4 March 2016

File No: 2016/107098  
Ref No: R/2015/41/A  
Your Ref: SSD 7388

**RE: State Significant Development Application for the redevelopment of the IMAX Theatre and surrounding public domain (SSD 7388), 31 Wheat Road, Sydney**

**Attachment A - Enhanced Public Domain Area at the Darling Harbour Waterfront**

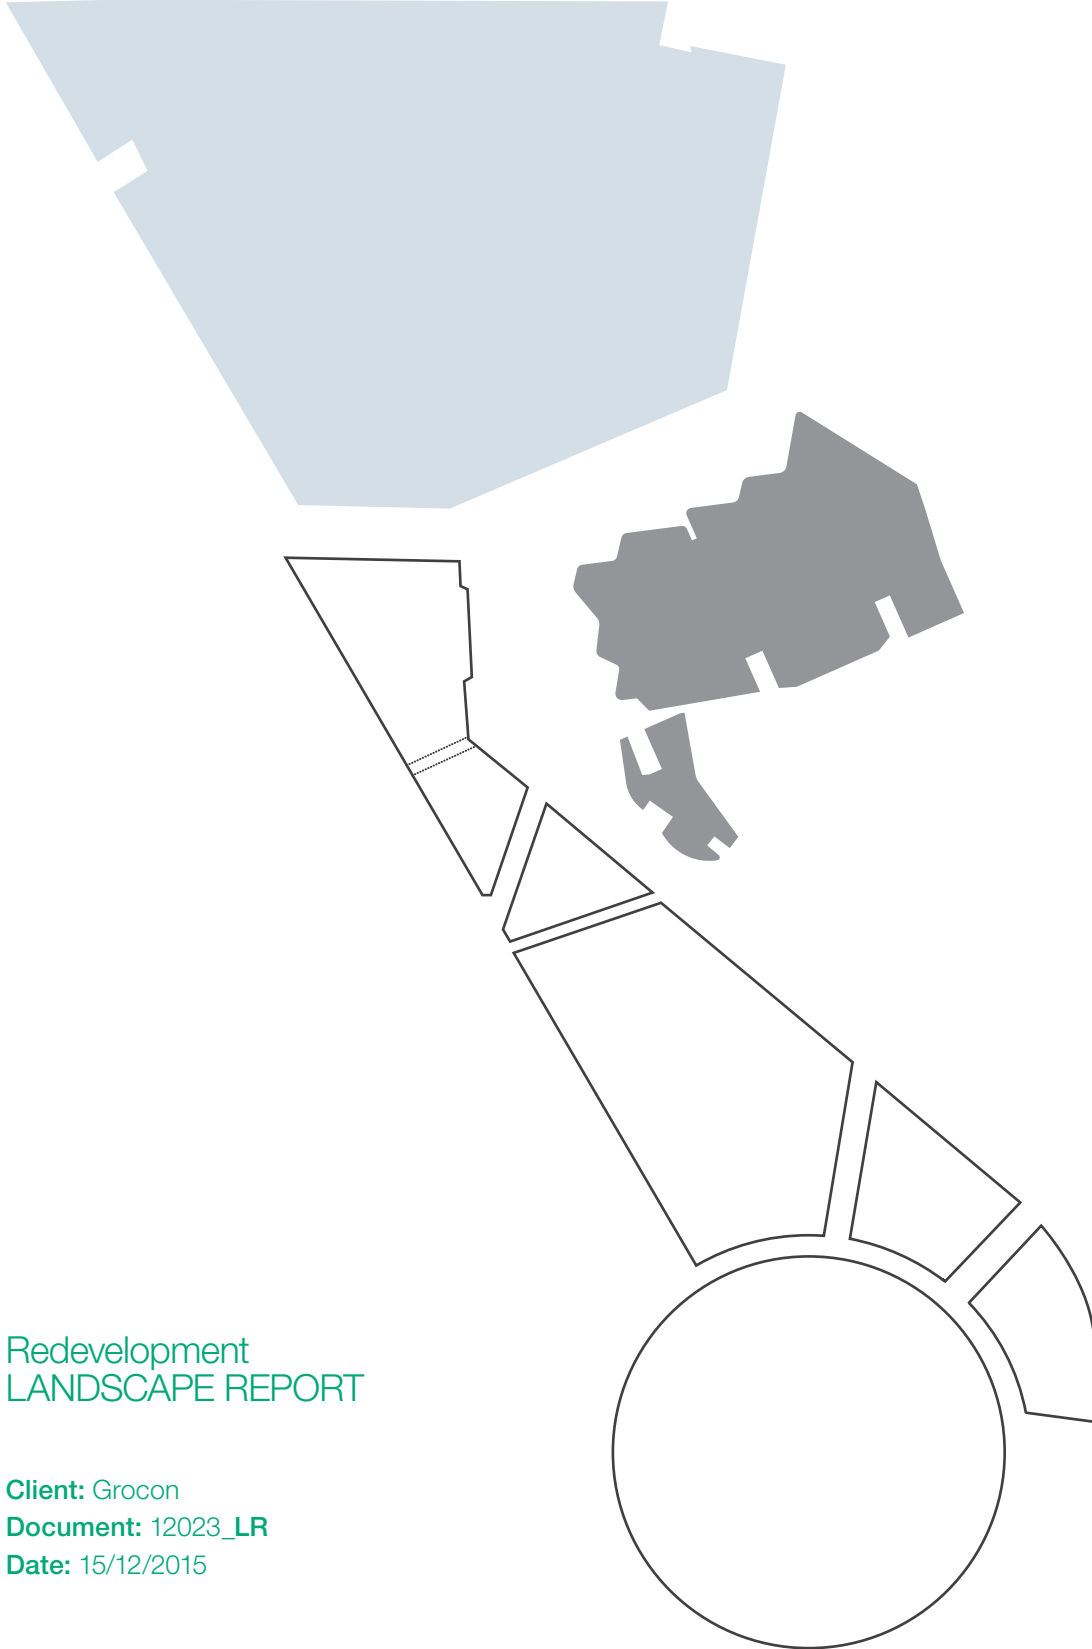
16. The entry to the hotel lobby is located away from the main pedestrian area with no clear line of sight, particularly with the impact of the columns for the Western Distributor and the protrusion of the escalator into the public domain. It is recommended the relationship between the lobby and public domain be improved as follows (and shown in Attachment A):

- (a) the escalator is to be removed or relocated;
  - (b) the glass curtain wall to the hotel entry should be removed and a landing of wide steps, free of obstacles should meet the pedestrian promenade;

- (c) the space between the built edge and the waterfront must be wide enough for an emergency vehicle to move, with minimal disruption to pedestrian activities;

- (d) the porte cochere should be reduced to the absolute minimum size, and adequate space provided for waiting passengers and clear signage/wayfinding;

- (e) wayfinding will also need to be used to ensure access to the lobby is clear.
17. Concerns are raised regarding pedestrian safety and conflict between pedestrians and vehicles crossing the vehicle entry point and around the porte cochere area. No information is provided as to how pedestrian safety will be managed. The design should include a continuous footpath across the driveway crossover to emphasise pedestrian priority and improve awareness of pedestrians and thus safety. Driveway crossing widths should be narrowed as much as possible (preferably to 6m or less).
